WSU Indigenous Centre of Excellence

TTW-CIV-CAN-002 – Turf Cell Installation and Maintenance Strategy & Responses to NSW Heritage

This memo outlines the details and standard maintenance requirements for the proposed turf cell system to be used in the new P1 carparks as part of the WSU Indigenous Centre of Excellence project. TTW Civil responses to queries from NSW Heritage are also summarised in the memo.

ATLANTIS TURF CELL (OR SIMILAR APPROVED)
REFER TO PRODUCT SPECIFICATIONS

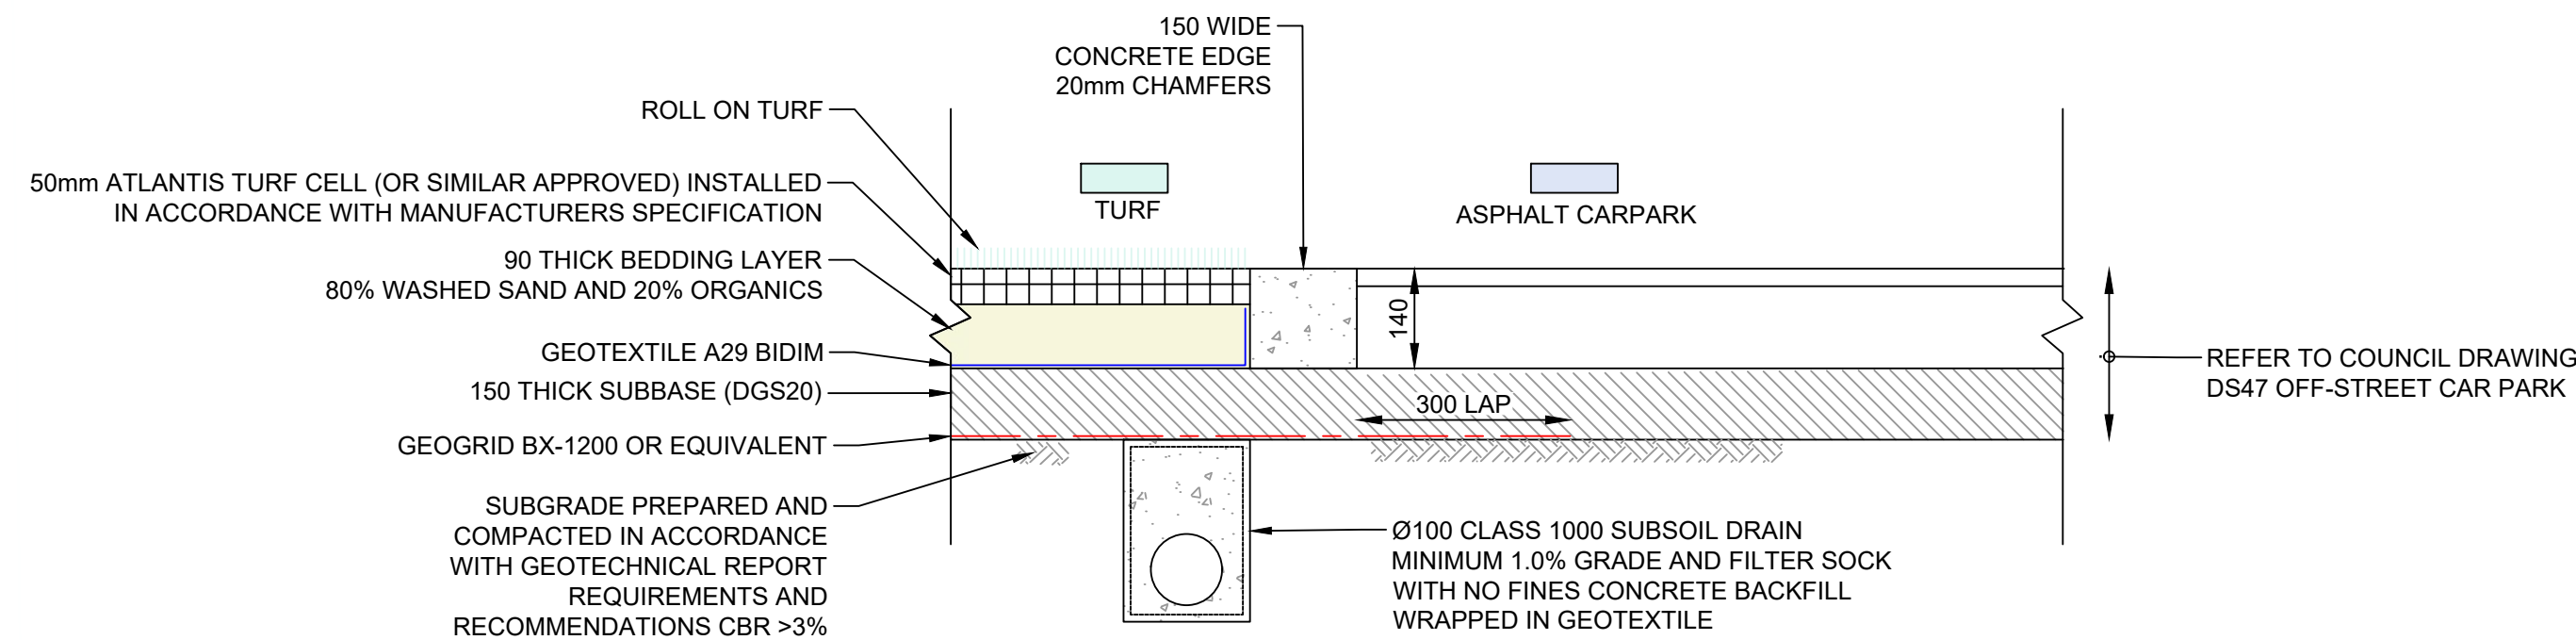
Queries	TTW Response
Heritage NSW continues to advise that the east and west parking areas, which will replace areas of soft landscaping, will have an adverse impact on the landscape character of the SHR item. We note the proposed use of turf cell to reduce visual impacts, but this will not reduce the visual impact of the cars themselves. We recommend that the east and west carparks be reduced in area and number of parking spaces to reduce their visual dominance. We also recommend that the carparks be laid out more efficiently to minimise the amount of bitumen driveway required to service the parking spaces. Obviously, the optimal heritage outcome would be that no temporary parking be provided within the SHR curtilage but it is noted that the loss of the existing 284 spaces is significant in number. Please provide detailed justification for the proposed number of carparking spaces. Limiting the temporary parking to 150-200 parking spaces and the resulting redesign of the east and west carparks would reduce the impacts to the heritage significance of the SHR Item.	The most efficient layout for any car park is to provide double-sided aisles with 90-degree parking spaces. This is implemented in almost all areas of the proposal except for the northern aisle of the east car park and the southern section of the west car park. In both cases, only a single-sided aisle has been provided because to expand the footprint any further would require removal of existing trees. The proposed layout achieves a balance between parking efficiency and impacts to planting and landscaping. The planning application for the ICoE development already relies on an improvement in travel behaviour and a shift away from car travel. Both TfNSW and Council have specifically provided comments through the planning process outlining the importance of providing the full capacity of replacement parking, to alleviate parking impacts on the surrounding residents.

The turf cell systems are proposed for use in parking bays only. Areas subject to frequent vehicle movements, including driveways and traffic aisles, are more susceptible to wear that can damage the turf and lead to loss of grass cover. Accordingly, conventional asphalt pavement is proposed for driveways and traffic aisles within the car parks. This approach is supported by correspondence with turf cell suppliers, as provided in the attachments.

The recommended installation detail and maintenance schedule are intended to ensure the long-term health, performance, structural stability, and appearance of the reinforced turf areas.
